CITY RESPONSE FORM

RESPONSE PROVIDED ON July 20, 2018 CAO17-003

SCALE: 1"=5'
 SHEET: 4 of 5

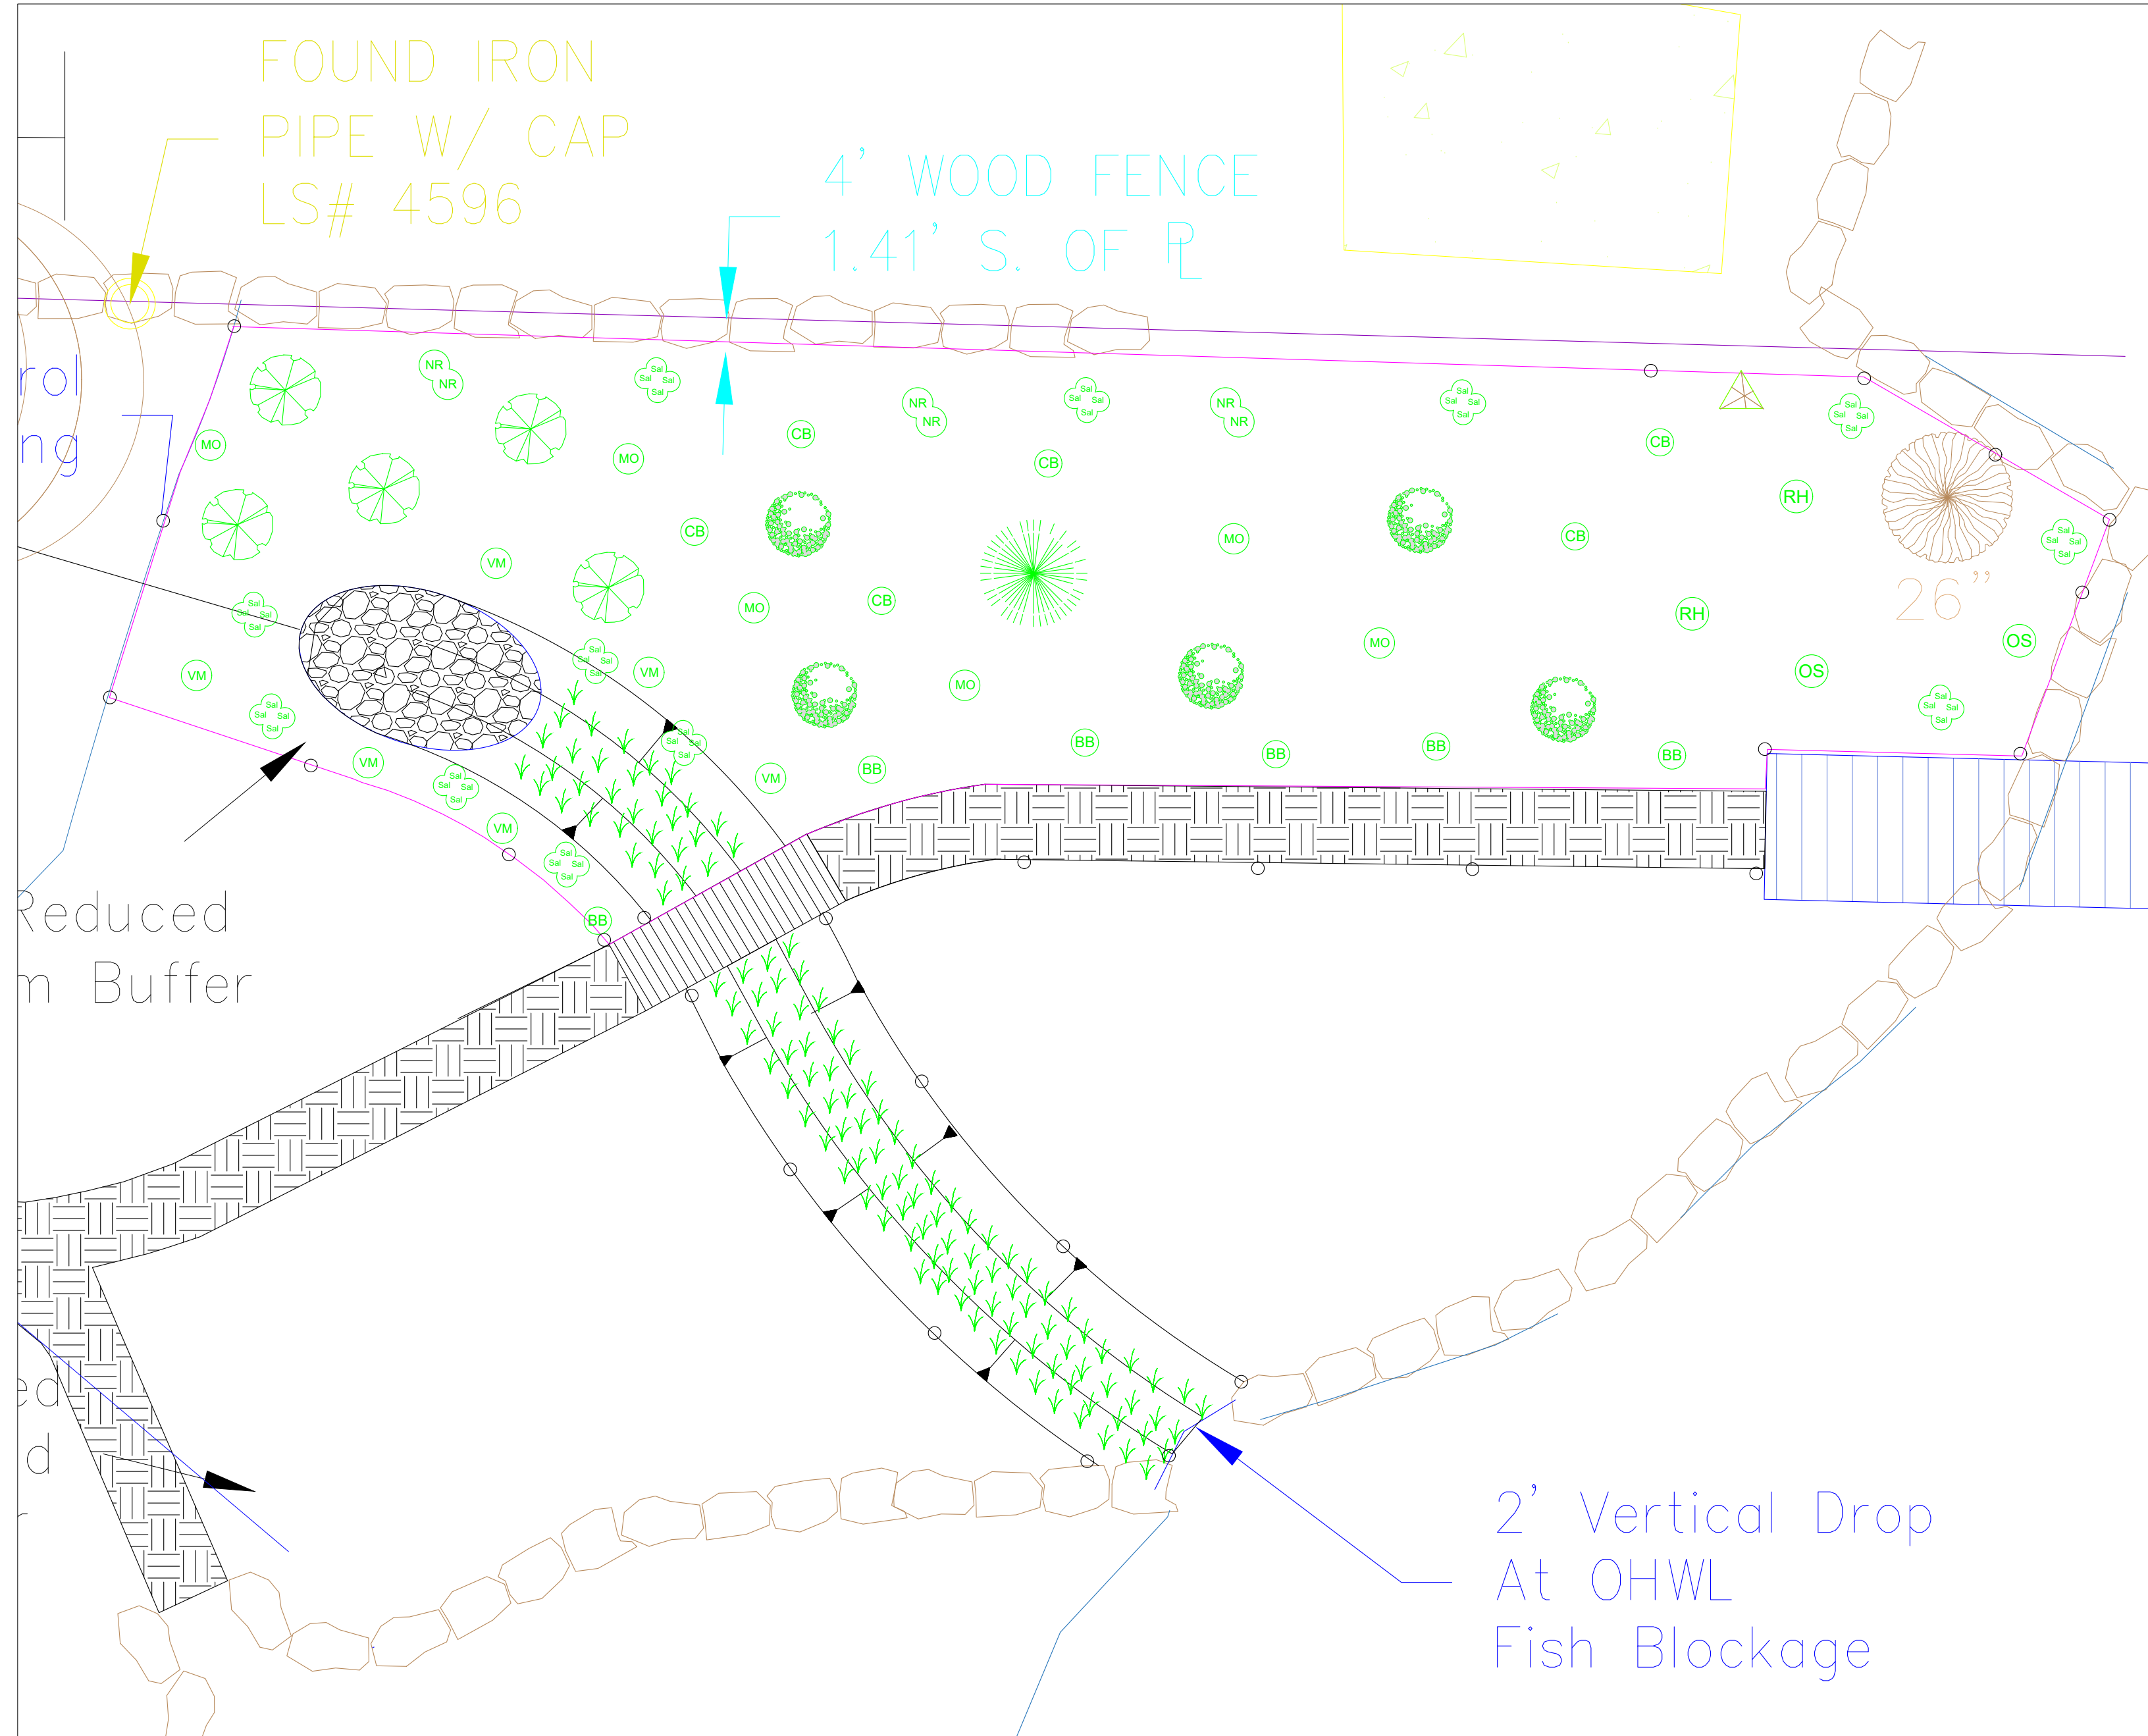
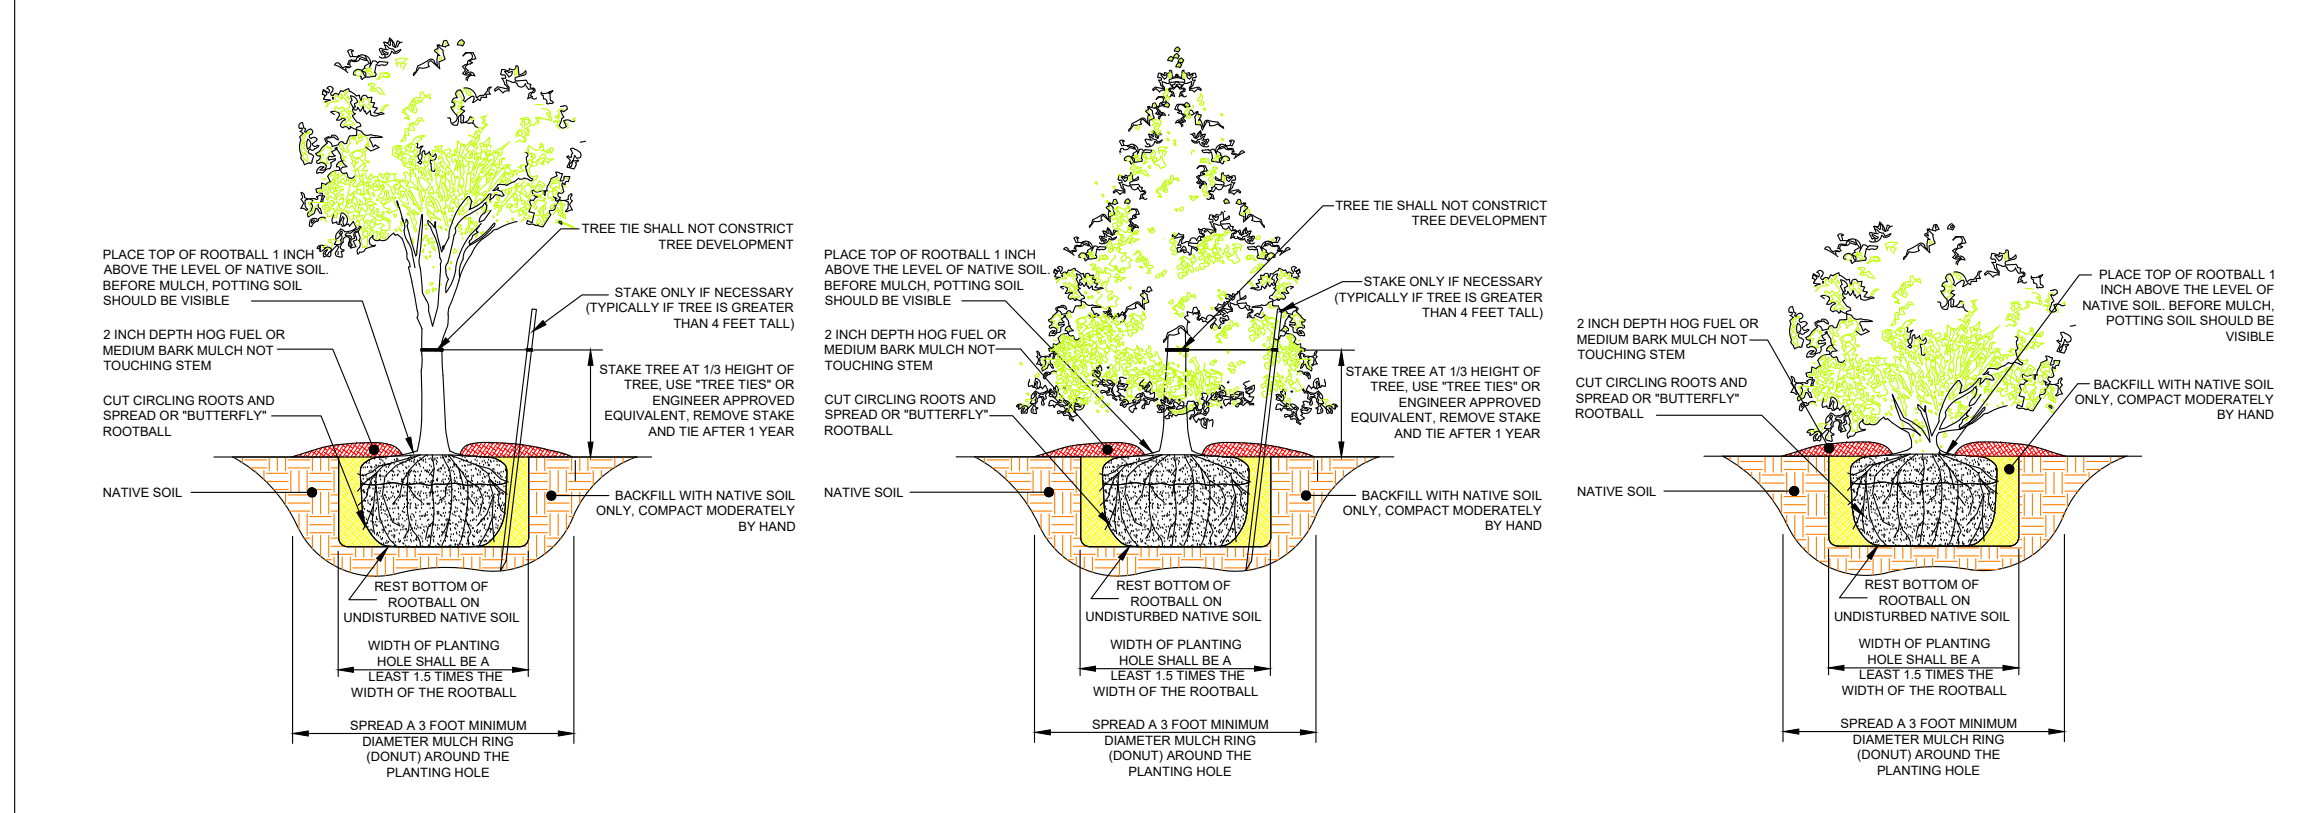
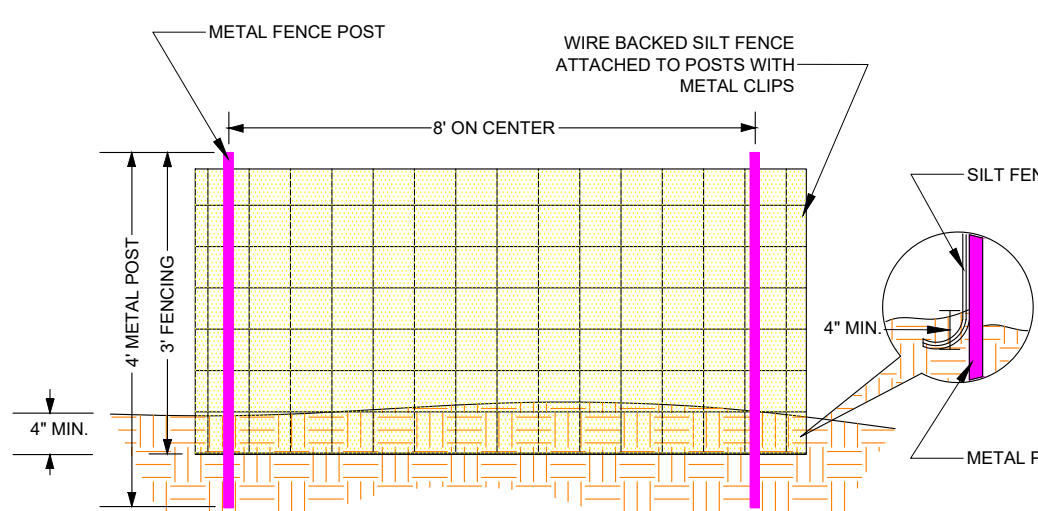
<p>4. Please provide additional detailed information for the proposed fish blockage removal. Provide the total area of excavation and grading within the stream, the proposed construction sequencing, the engineering design versus conceptual plan, and a statement that the remaining rocks in the stream channel will not block fish passage or removal of the remaining rocks.</p>	<p>a. The total area of excavation and grading of the watercourse has been added to Sheet 4 of 5. b. The details of construction sequencing has been added to Sheet 4 of 5. c. More detailed design has been added to sheet 4 of 5. d. The following statement has been added to Sheet 4 of 5: <i>The remaining rocks will not block fish passage or removal of the remaining rocks.</i></p>	<p>Ok Section of code that conflicts Comment</p>
<p>5. Given the location of the stream mouth at the transition from the hard stabilization structure and beach, please use soft shoreline stabilization for the shoreline structural stabilization proposed in Details 4.2a and 4.2b of the Buffer Reduction Mitigation Plan.</p>	<p>See above response 4c) where cedar logs have been chosen in the detailed design as soft shoreline stabilization.</p>	<p>Ok Section of code that conflicts Comment</p>
